**WEST SUSSEX COUNTY COUNCIL
HIGHWAYS AND TRANSPORT SERVICES CONSULTATION**

SUBJECT: FP/126/08 - Outline application for the erection of 1 x 3-bed chalet house on land at rear of 7 The Crescent

17, The Crescent, Felpham, West Sussex

Drawing	Location Plan	Scale
	Site Plan	1:1250
		1:1500

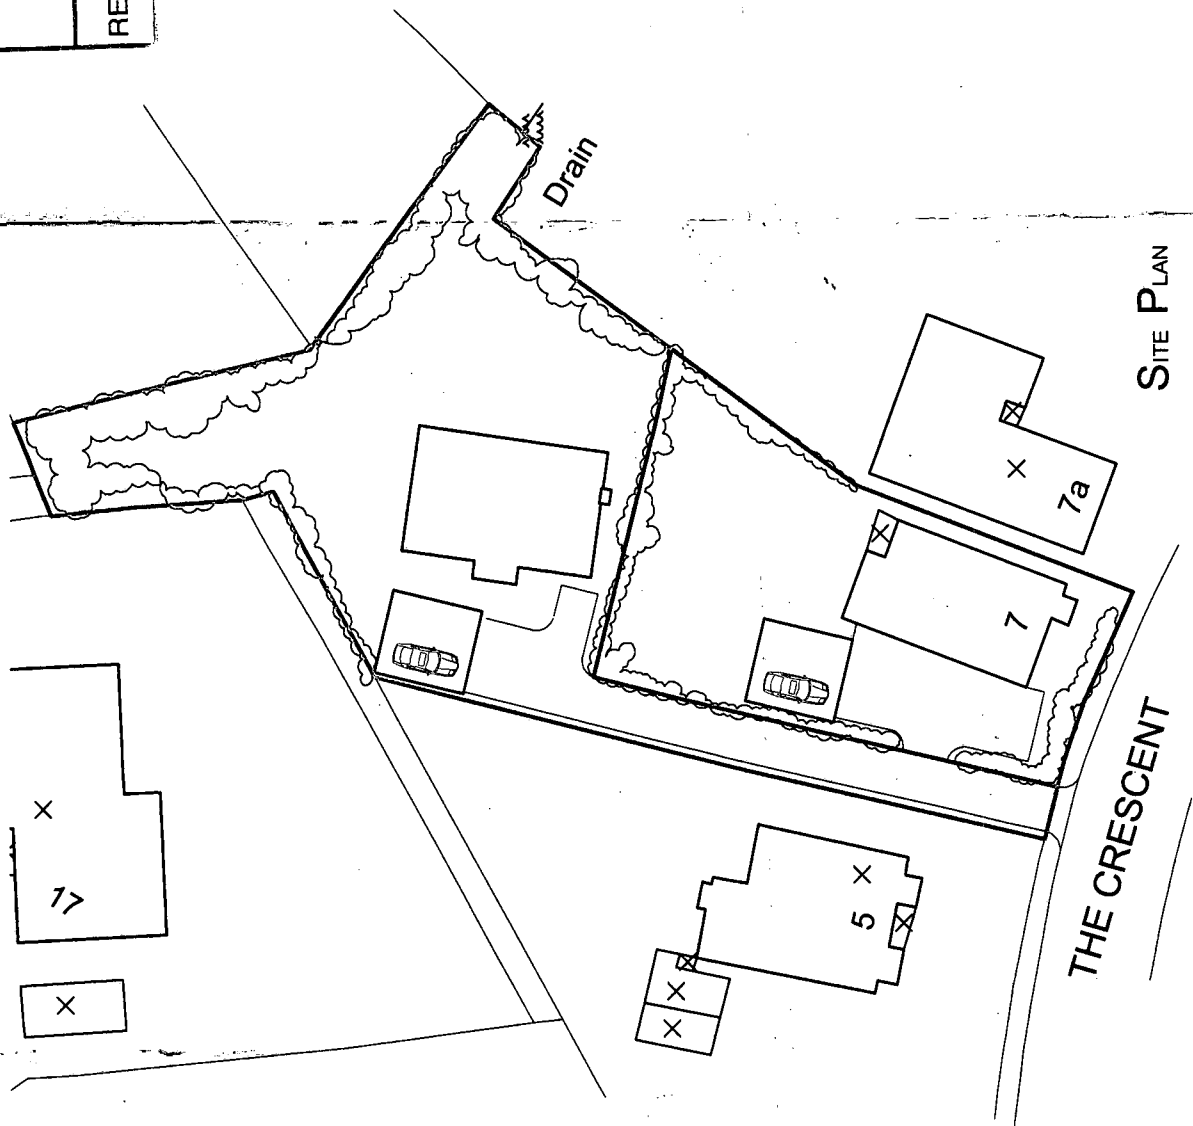
The proposal is for a 1 No 3 bedroom chalet bungalow unit with access onto The Crescent via an existing access point. This proposal has been considered using drawings submitted with this application, in conjunction with other available WSCC map information. A site visit can be arranged on request.

From an inspection of the plans alone, there is no apparent visibility issue at the point of access onto The Crescent. The Highway Authority would be satisfied that the concerns raised under FP/153/03 have been rectified successfully. I have also checked our most recently available verified accident records, which reveals there have been no personal injury accidents in the vicinity of the existing point of access, indicating a low risk of highway safety issues with this proposal. There should be provision of secure and covered cycle parking if this application was to obtain planning permission.

No dwelling, hereby approved, shall be occupied until covered secure cycle parking spaces have been provided in accordance with a detailed construction plan to be submitted to and approved by the planning authority.
